STERLING RANCH FILING 3 LANDSCAPE PLAN

STERLING RANCH FILING NO. 3

Landscape Plan_V1 redlines.pdf Markup Summary 11-30-2021

LANDSCAPE PLAN

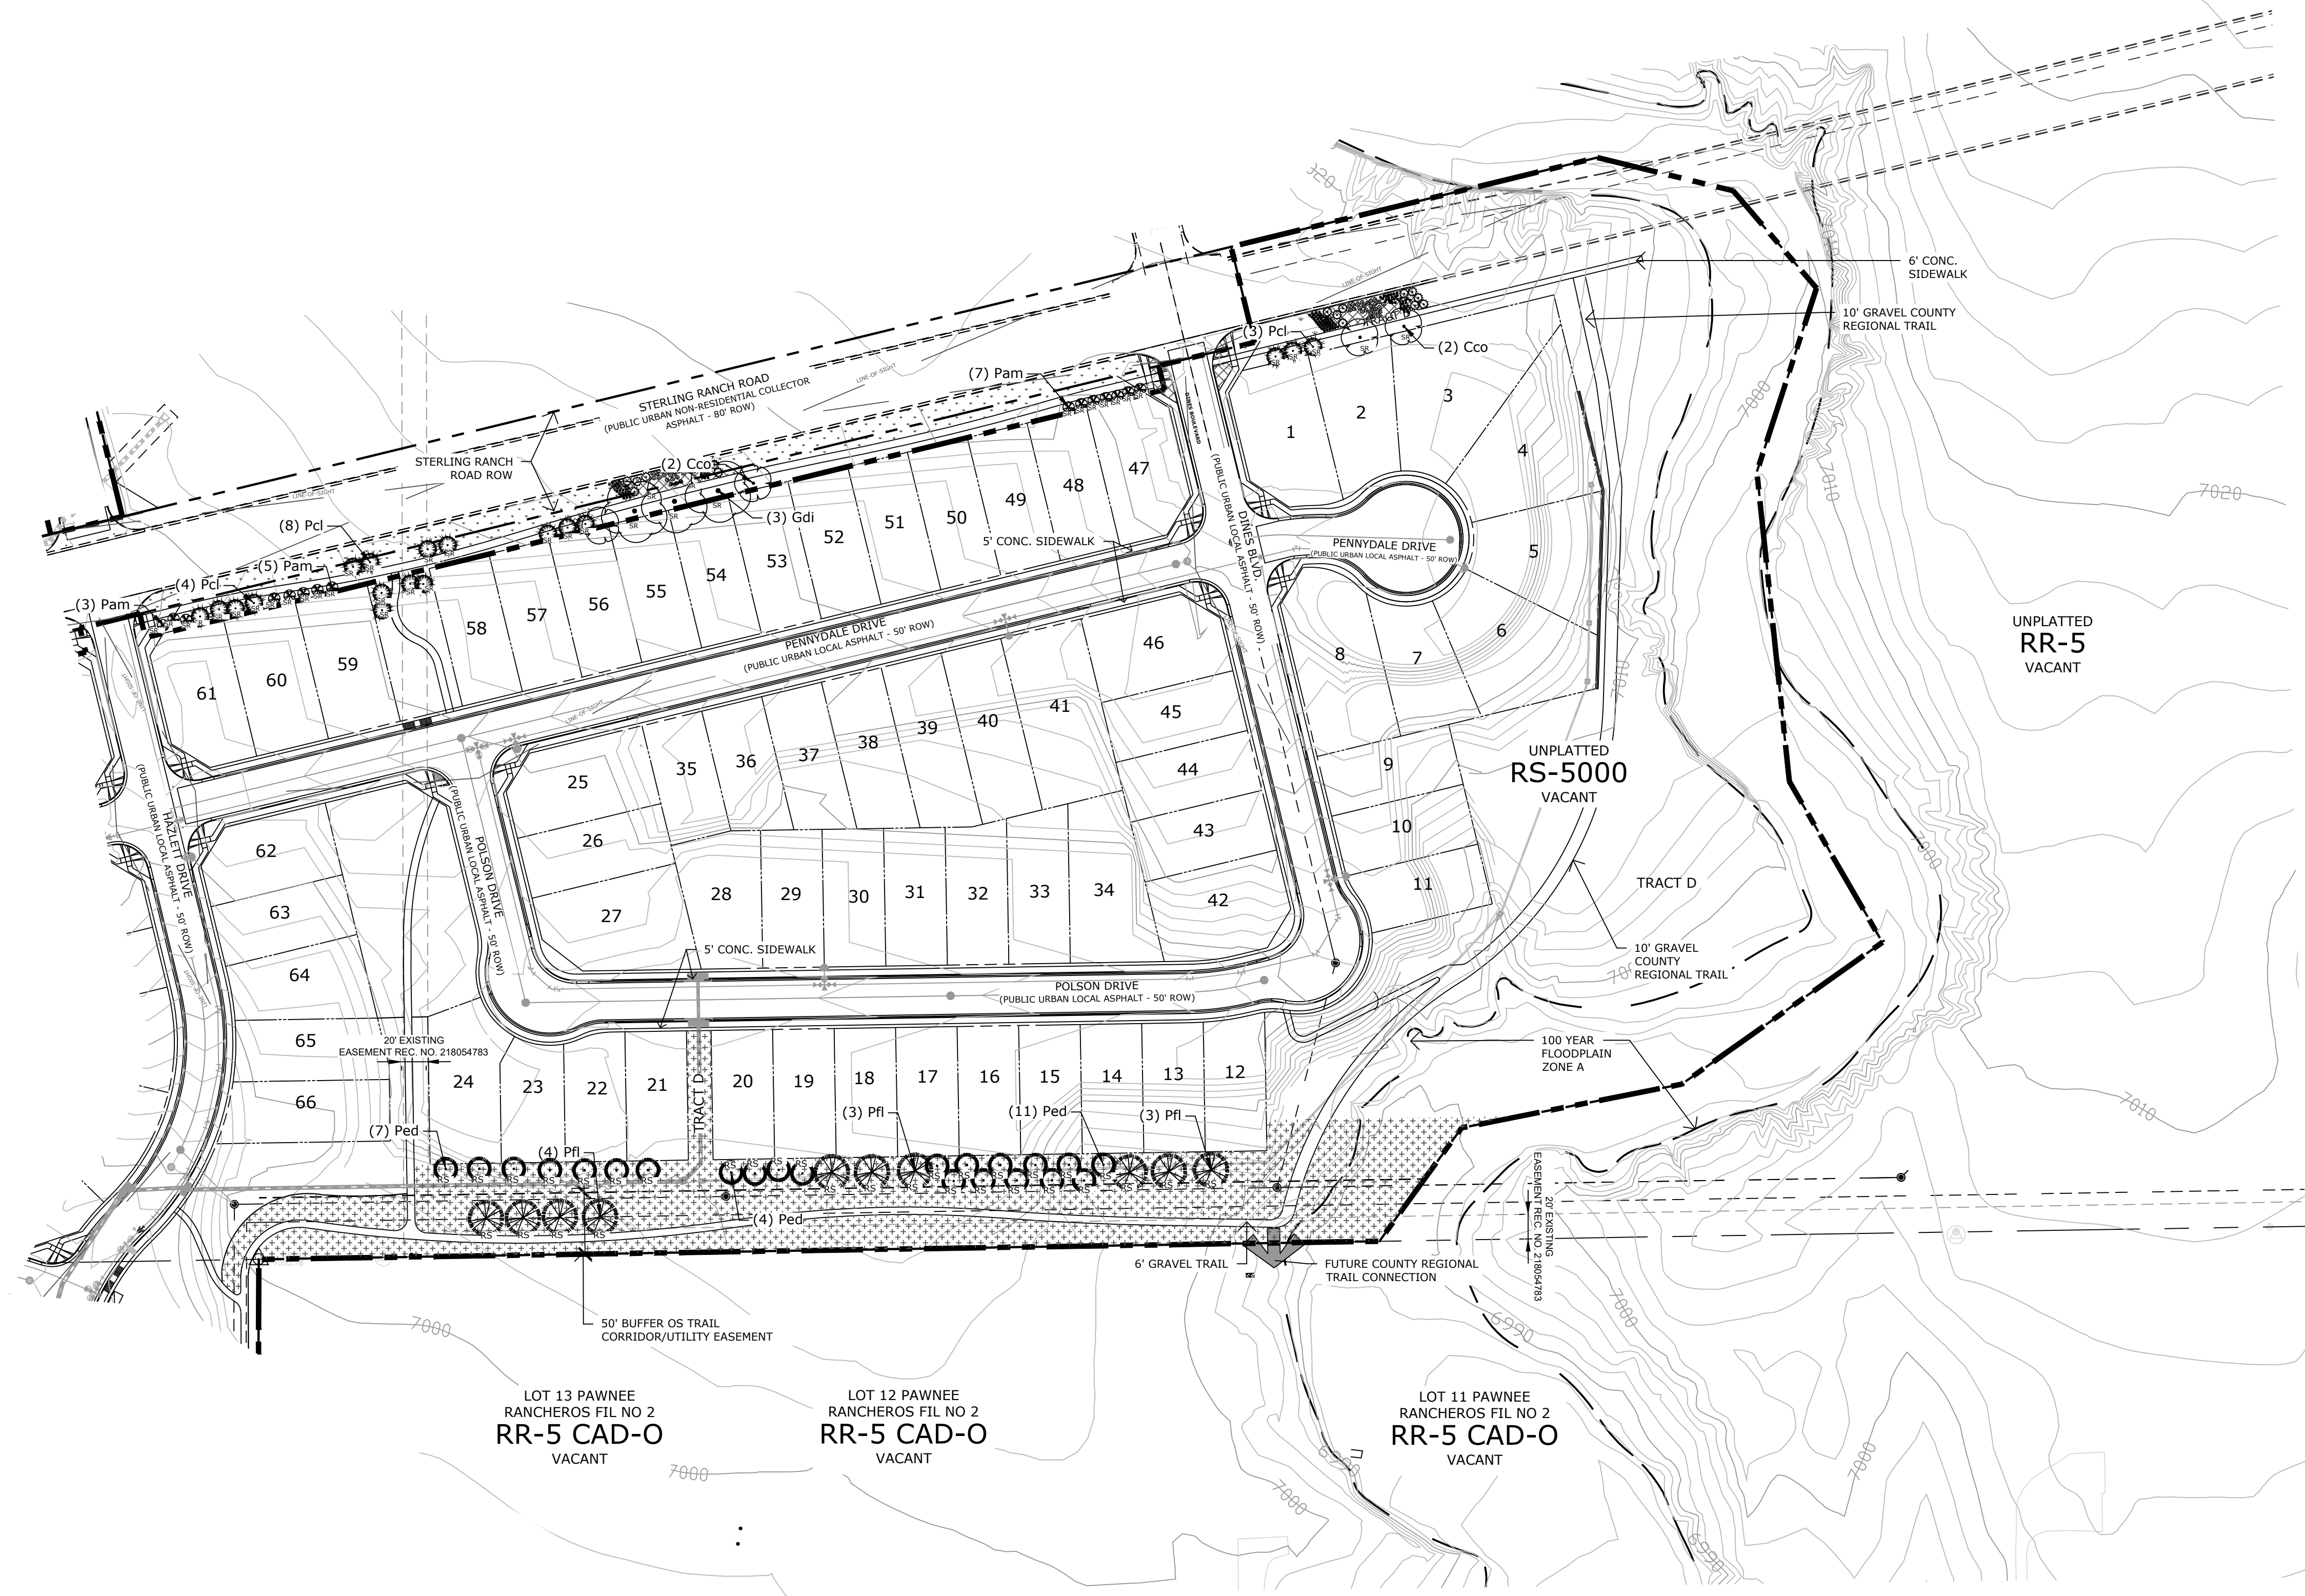
this should match the plat

verify all trees and shrubs are outside of ROW please.
